# CITY OF ALBUQUERQUE

March 24, 2021

Re: **Church of Christ**  
**102 Camino De La Sierra NE**  
**Traffic Circulation Layout**  
Architect's Stamp (L23-D024A)

TRAFFIC CIRCULATION LAYOUT

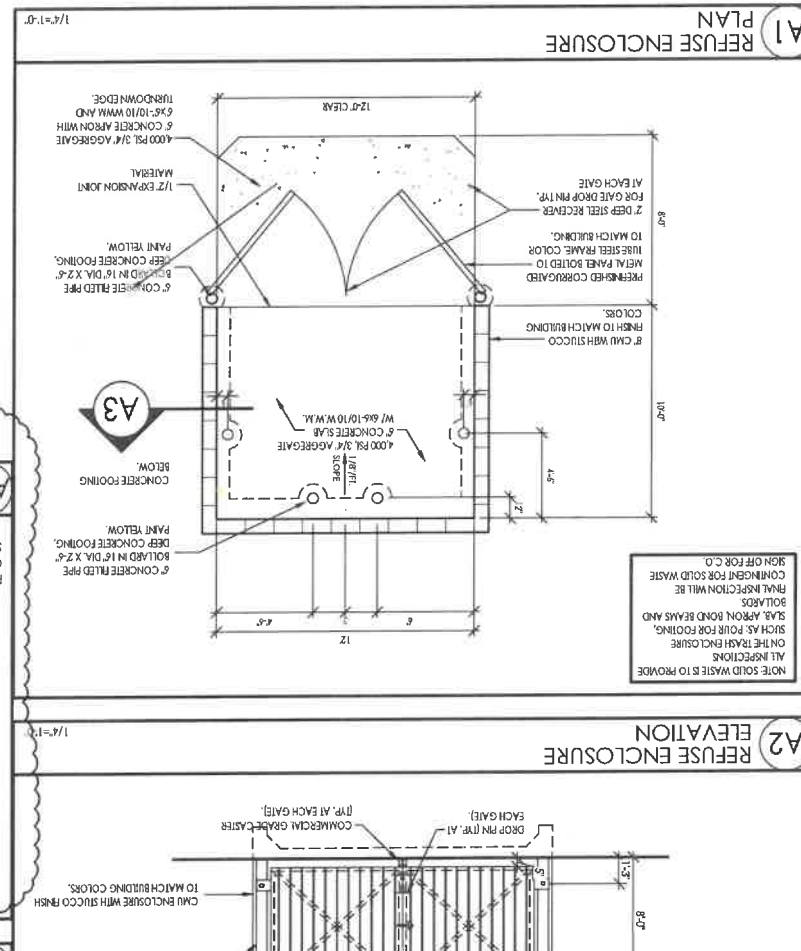
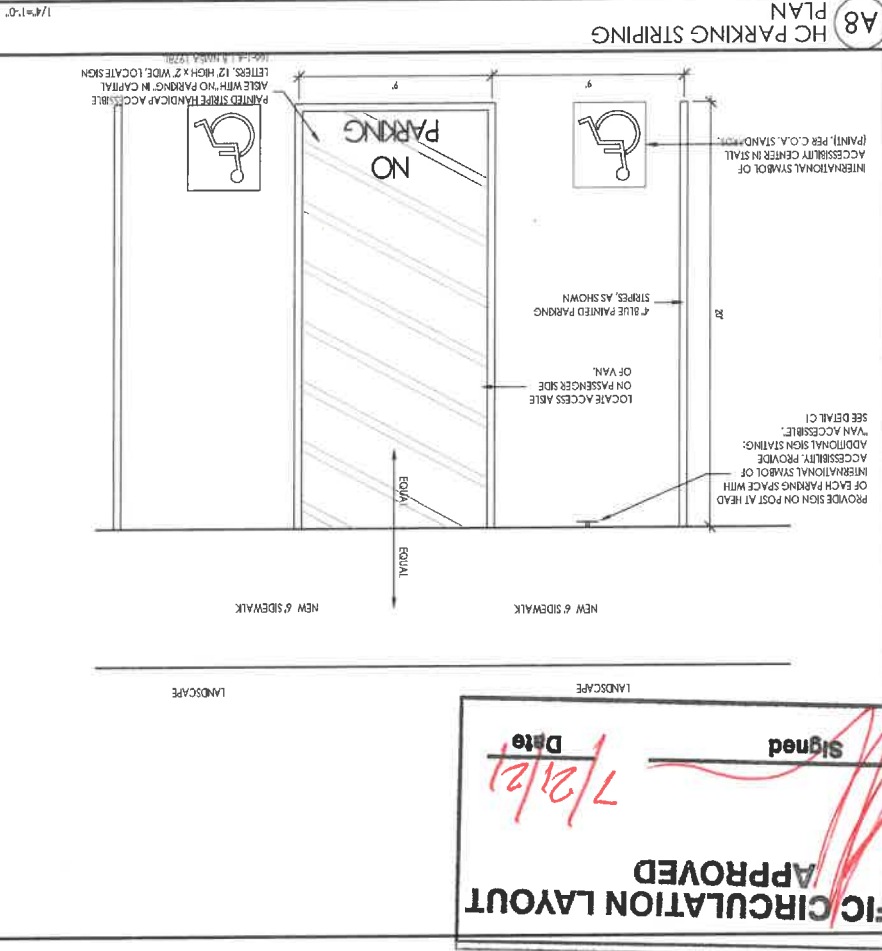
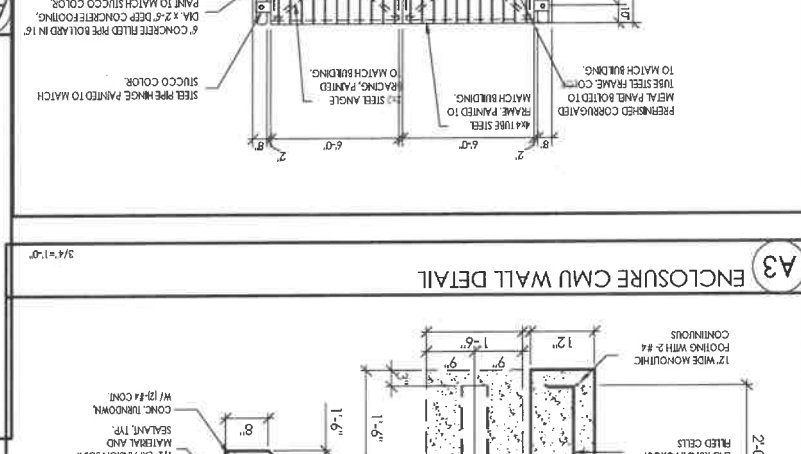
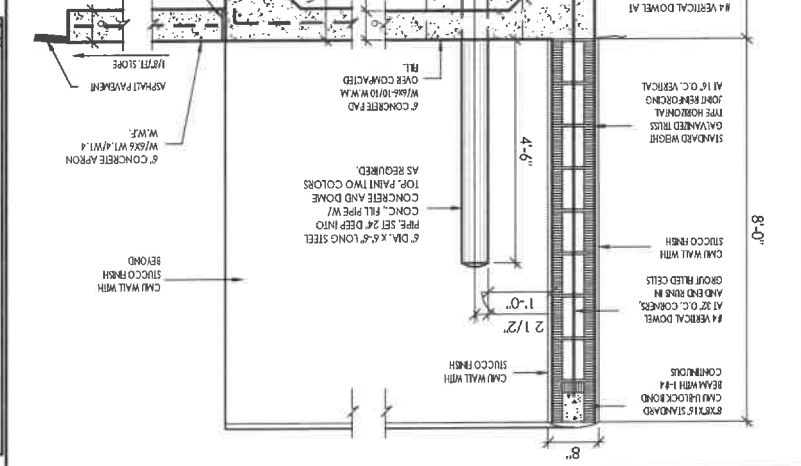
1. If there is an existing 10 ft public utility easement, you will need to provide the approved Plat showing this easement.
2. You will need to provide sidewalk on the whole length of the street frontage or obtain a sidewalk waiver from Jeanne Wolfenbarger.

3. All sidewalks along streets should be placed at the property line.
4. Proposed 6ft fence fronting alley way. A fence will need to be provided and make sure parking stall overhang doesn't encroach on proposed fence.

5. Wheel chair ramps with truncated domes will need to be provide for any public sidewalk fronting public street (If applicable).
6. Since the sidewalk is flush with the proposed pavement level, does note 6 need to be removed as well as detail reflected on sheet AS20.0/A11?

7. The proposed a 6 ft. wide ADA accessible pedestrian pathway from the public sidewalk to the building entrances has no key note to define the type of surface being proposed. Please provide some notes for these items.

8. You specified that there are no improvements so remove general D per you response for comments 23 and **24.REMOVE NOTE "All improvements located in the Right of Way must be included on the work order."**
